From: Susan Leeson
Sent: 15 November 2012 10:32
To: Daun Johnson
Subject: FW: Land at Oldlands Way - Non material amendment to BE/17/12 - Reconfiguration of the drive thru
Attachments: 4912_8584_0002K_BLOCK PLAN.pdf; 4912_8584_0004K_PROPOSED SITE PLAN.pdf; non material amendment form_signed.pdf

From: Sarah Carpenter [REDACTED]
Sent: 14 November 2012 13:40
To: Susan Leeson
Subject: Land at Oldlands Way - Non material amendment to BE/17/12 - Reconfiguration of the drive thru

Land at Oldlands Way - Non material amendment to BE/17/12 - Reconfiguration of the drive thru

DRAWING TITLE :-
Block Plan

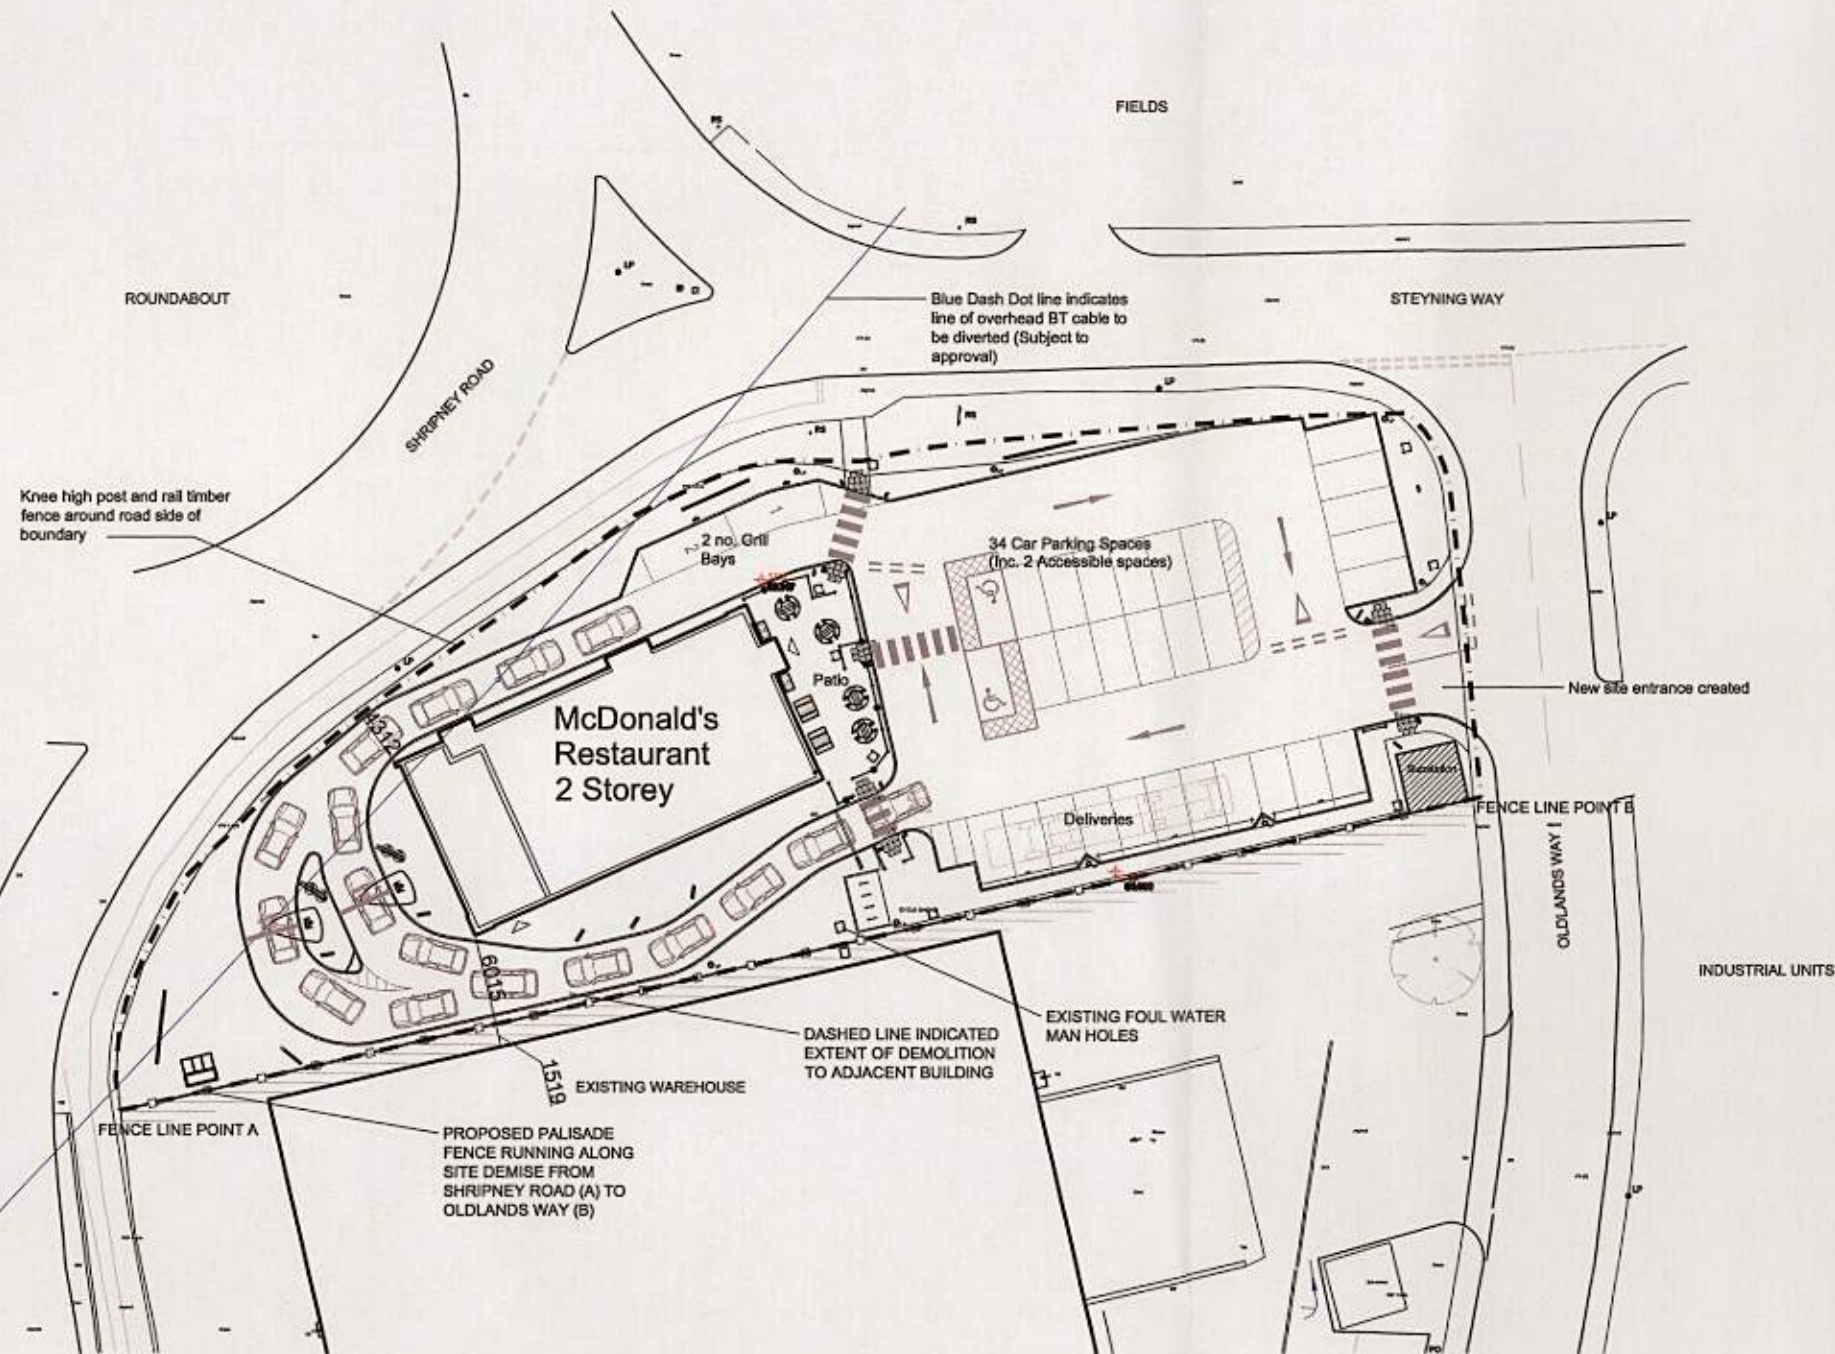
Further to our recent application for the construction of a freestanding restaurant and subsequent reconfiguration of the drive thru, our client has reviewed the site and assessed that the best configuration for the drive thru would be the side by side option. This will allow for two cars to order at the same time and thus reduce the times needed in the drive thru lane and queuing through the site.

The revised drawing also includes the perimeter fence to be introduced.

This is acceptable as an NMA
